Application for DCO by FOSSE GREEN
Representation by Interested Party reference F88728215
Deadline 6

Summary of Submissions

A Comments on REP5A-038- Applicant's Response to Deadline 5 submissions:-

Figure 3-2A SHEET 1

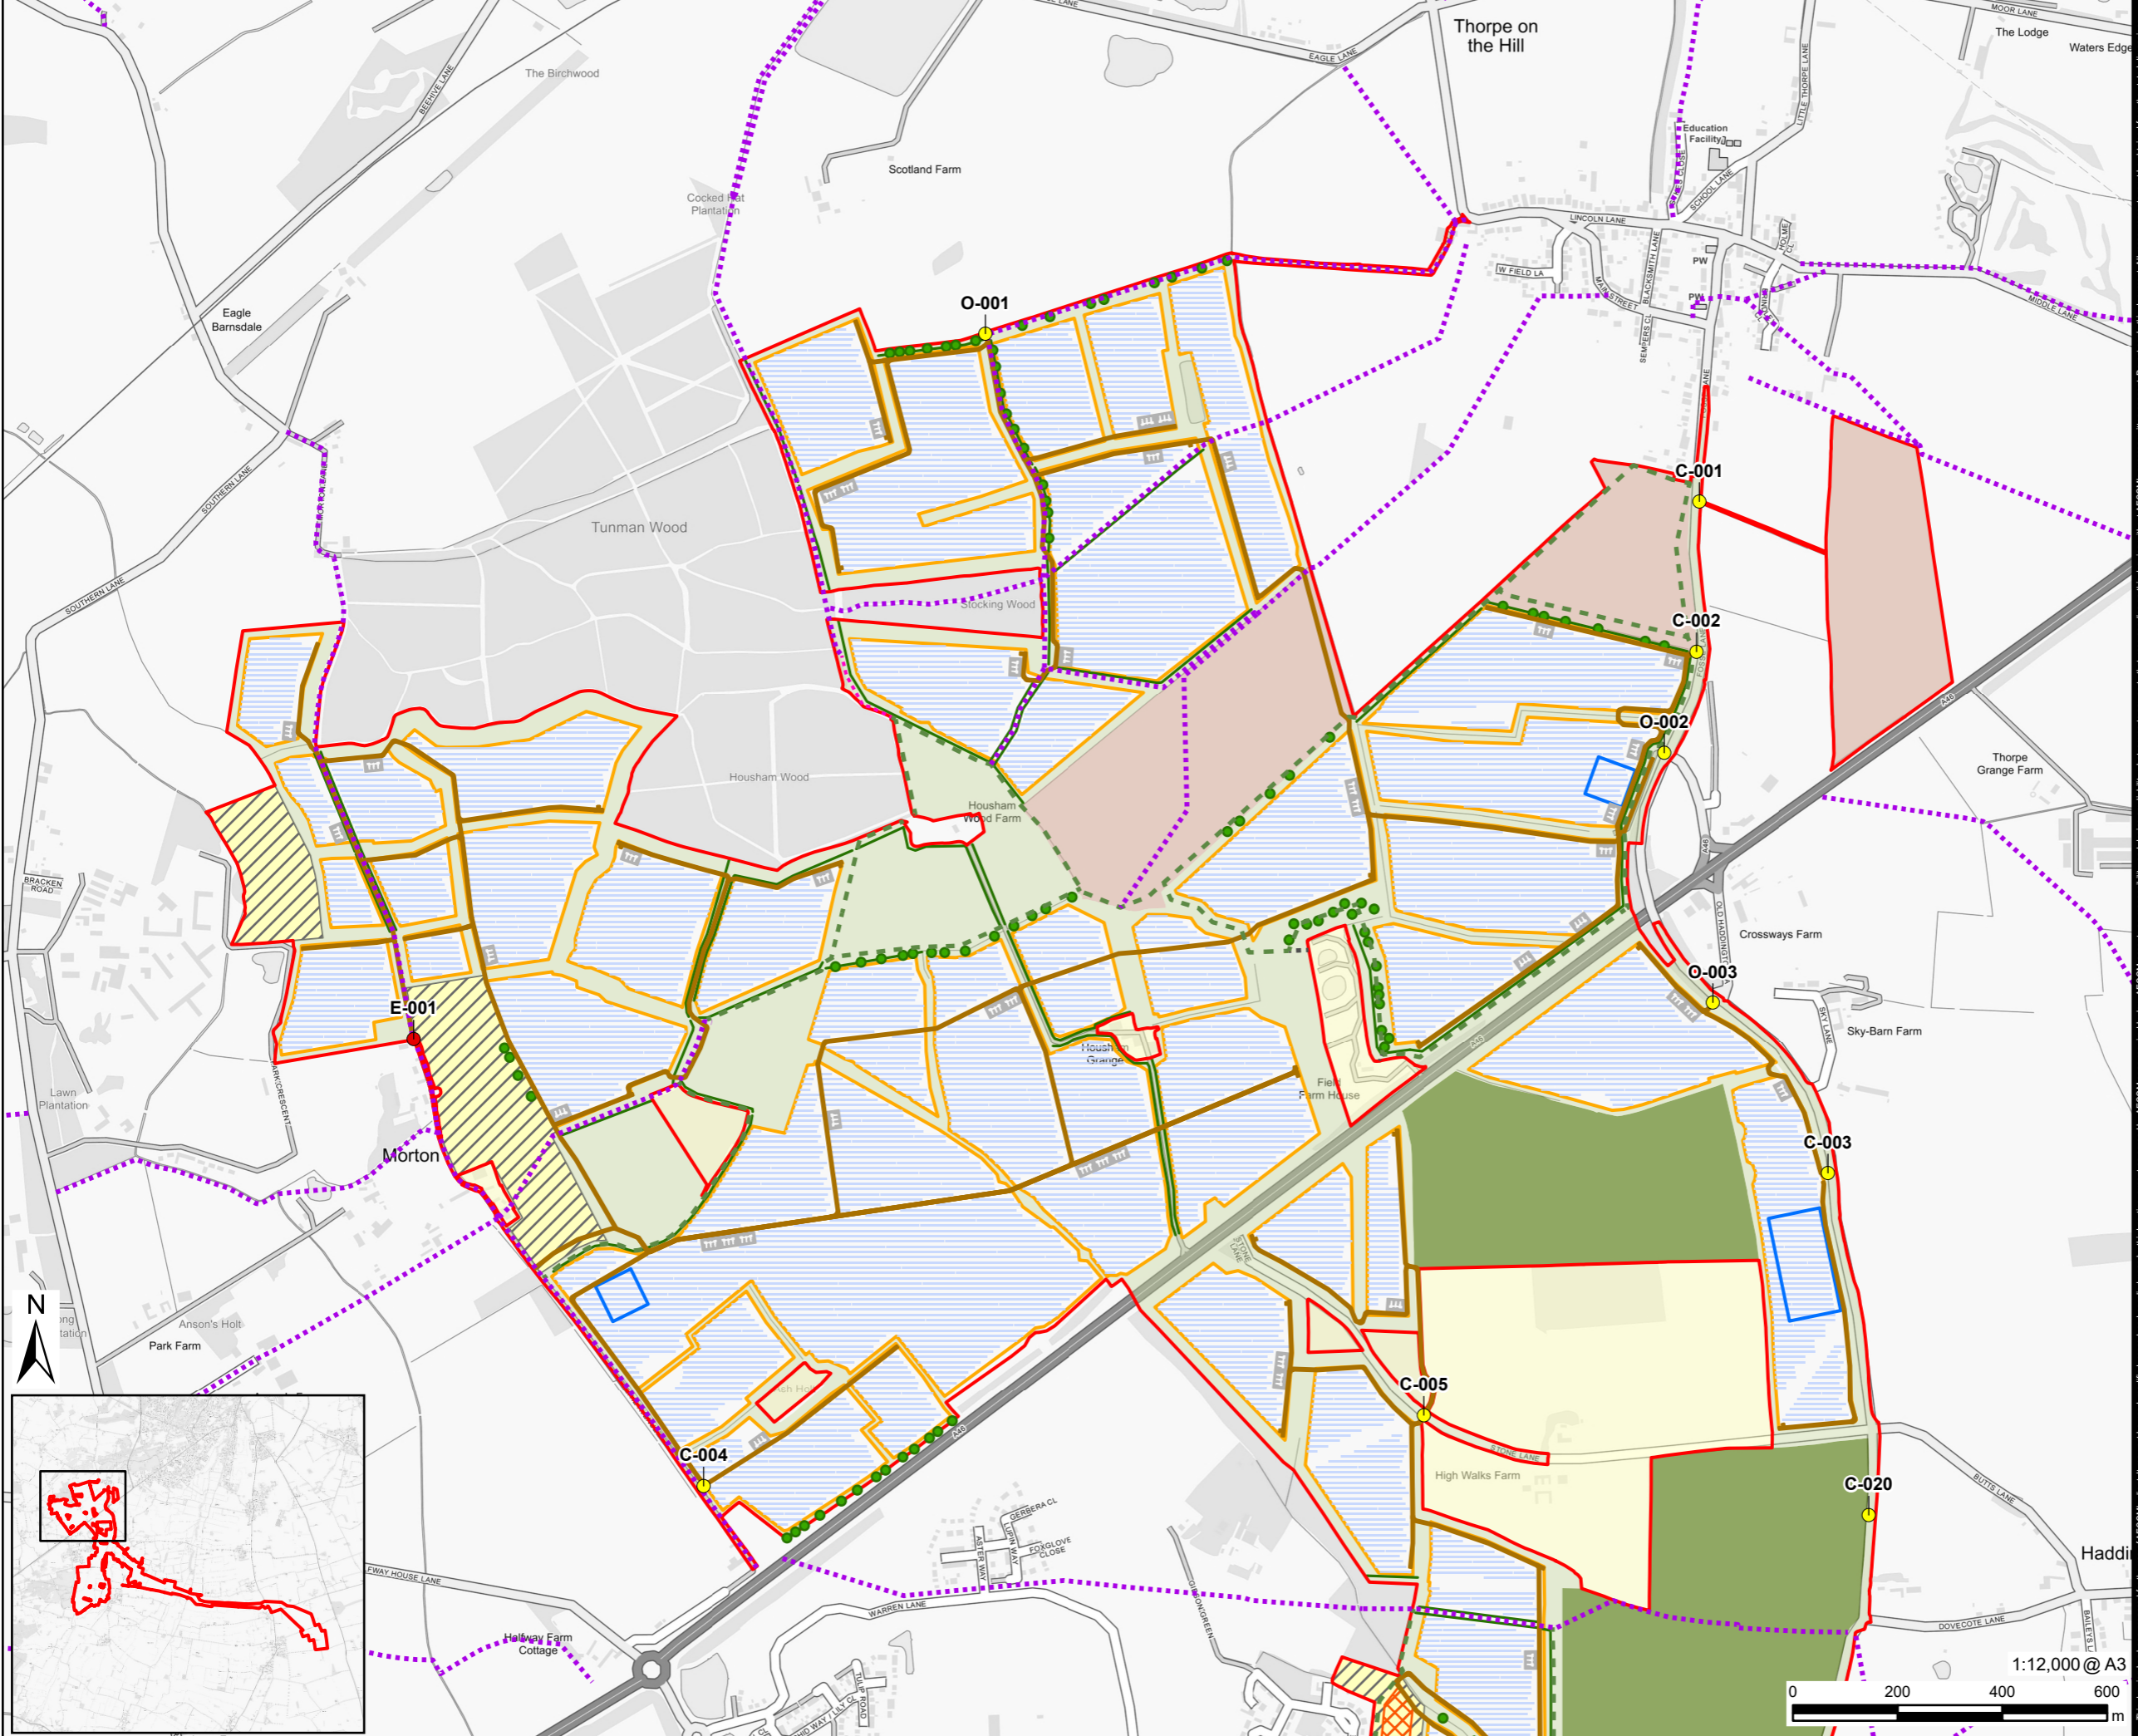
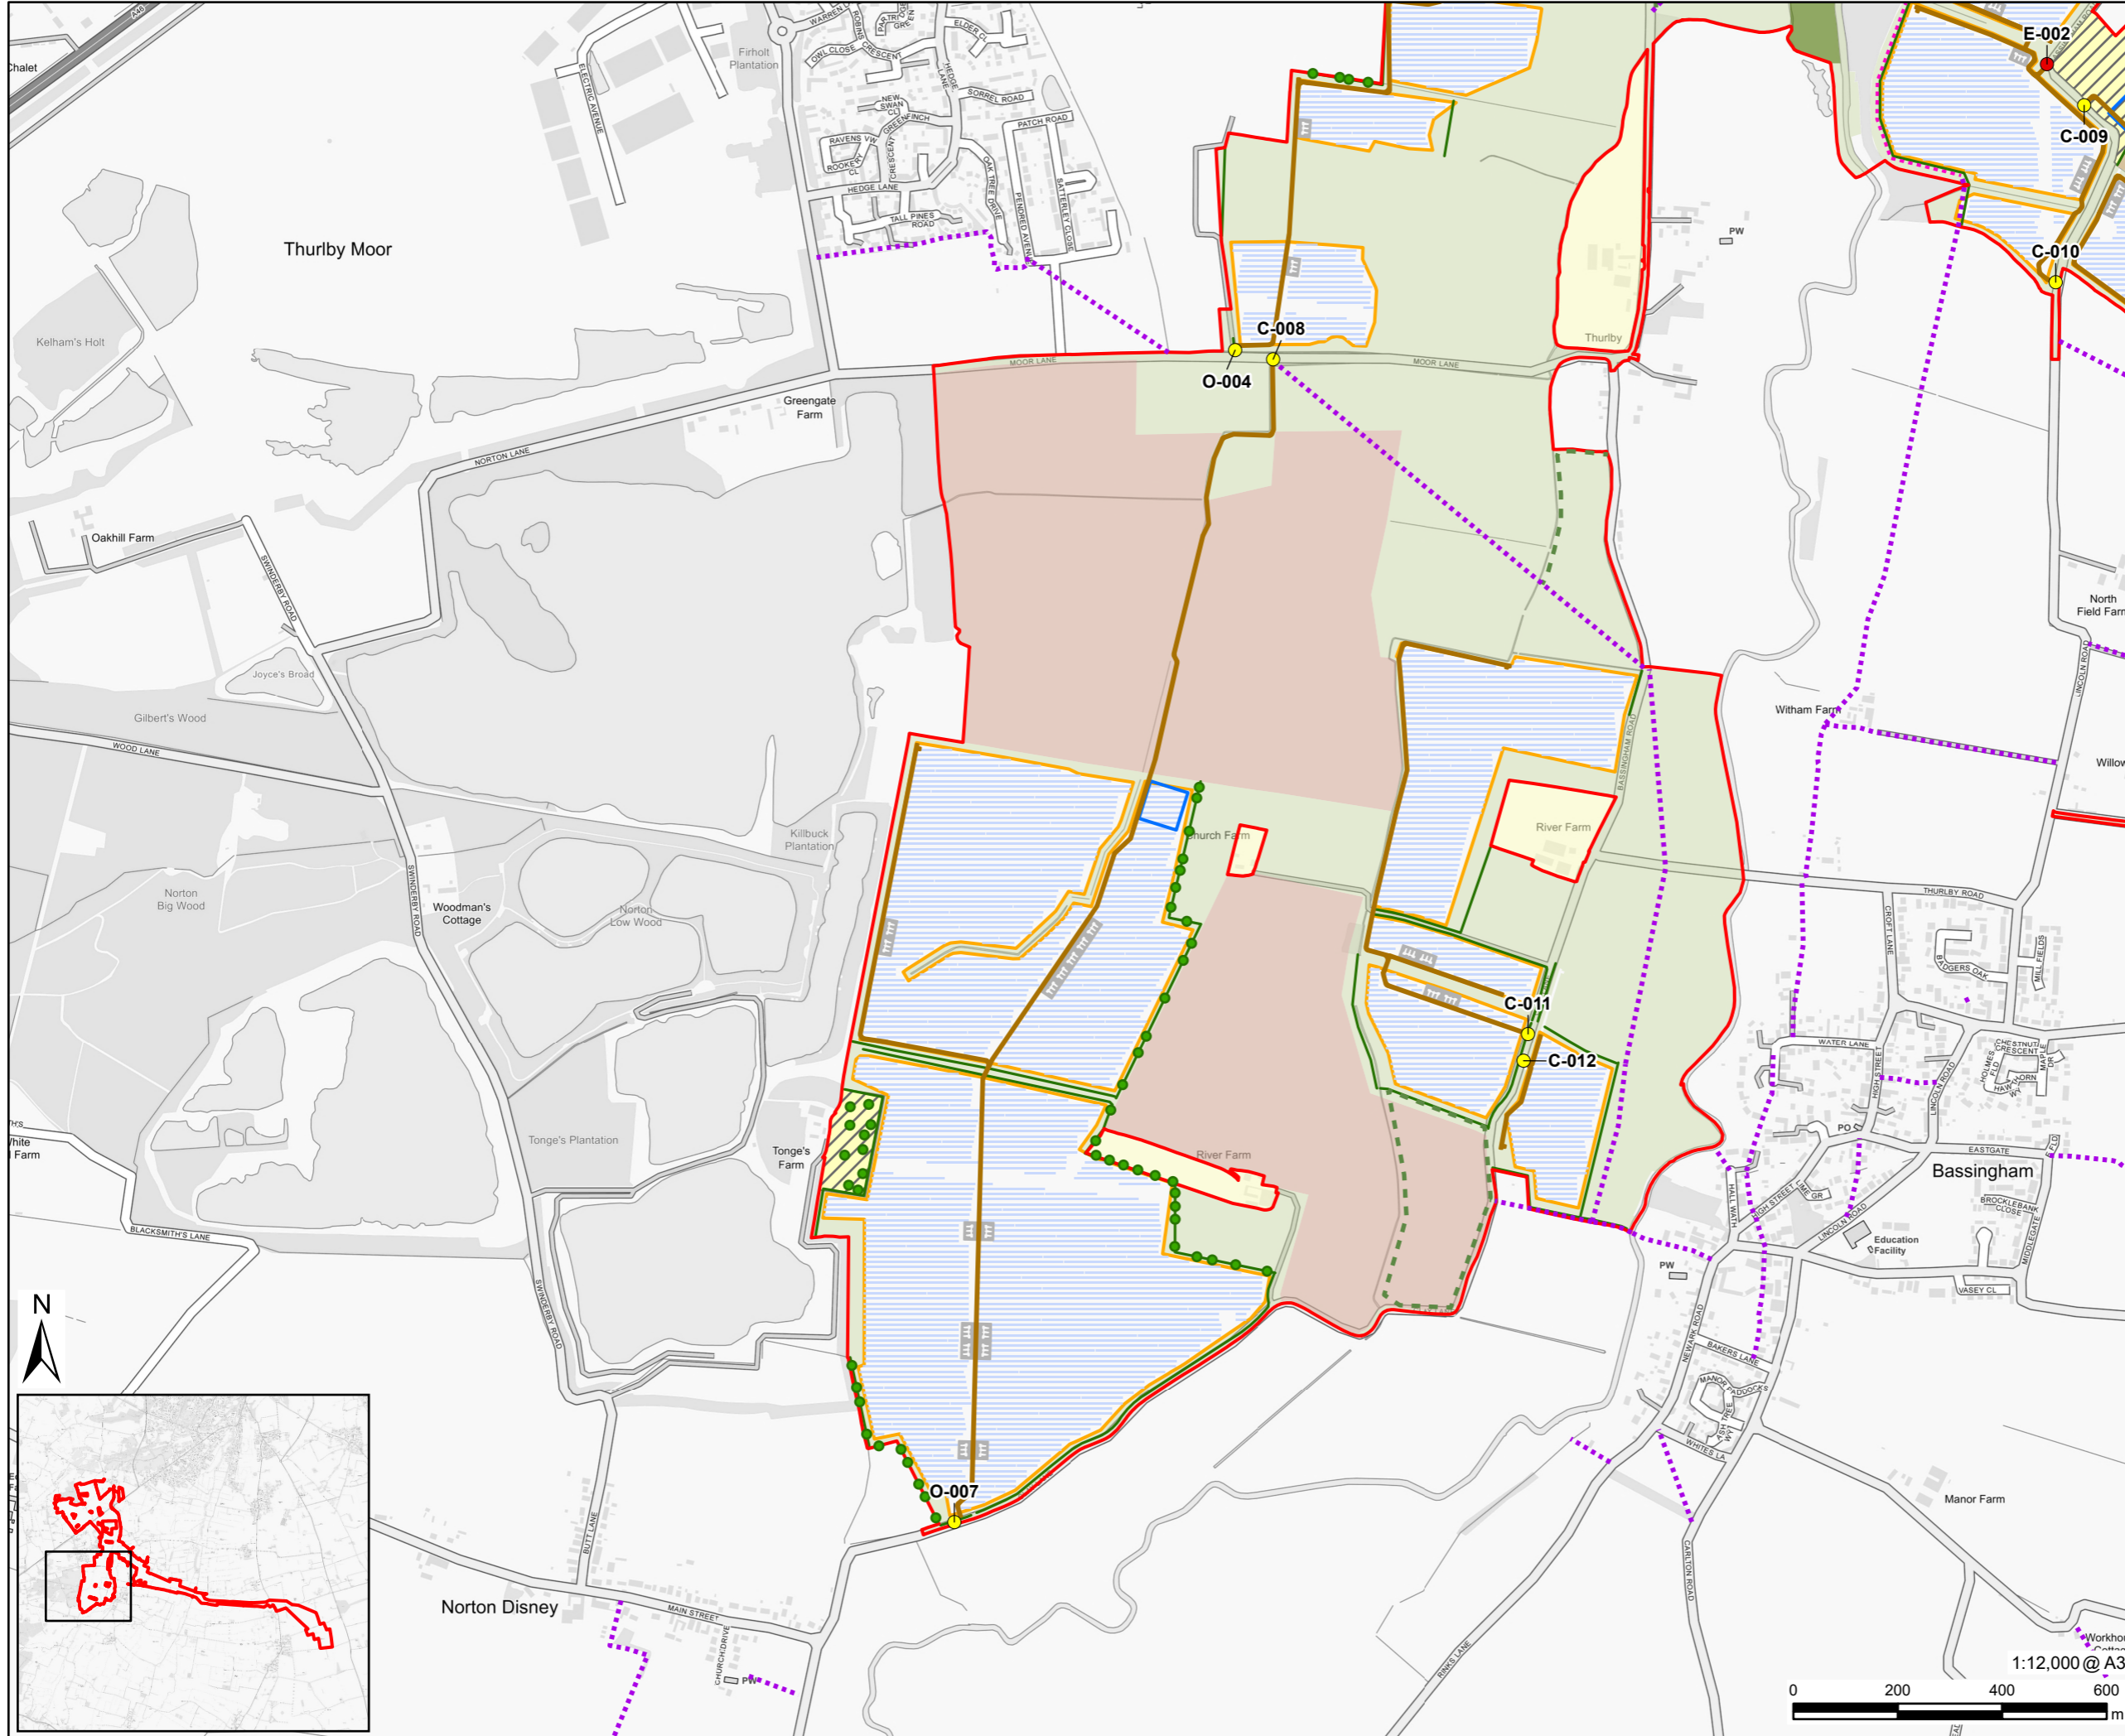
7.2.1 Whilst the Indicative Fixed South Facing Site Layout Plan (REP5-006) and Figure 3-2B Indicative Single Axis Tracker Site Layout Plan (REP5-007) are indicative, it would surely not have been too difficult to show the location of the route of the permissive path so as to be consistent with other plans. Whilst those indicative plans show the permissive path within the highway and the Streets, Rights of Way and Access Plans (REP-004) show the permissive path to the west of the highway, there is a further version shown on the FLEMP Appendix A Figure 7.15.1 (REP5-017) Sheet 9 which shows the permissive path partially within the highway and partially to the west. Three different versions of the route of this path!

Figure 3-2A Indicative Fixed South Facing Site Layout Plan (REP5-006) and Figure 3-2B Indicative Single Axis Tracker Site Layout Plan (REP5-007) are indicative whilst the Streets, Rights of Way and Access Plans (REP5-004) are detailed secured plan showing the proposed permissive path at Clay Lane adjoining the western edge of the highway.
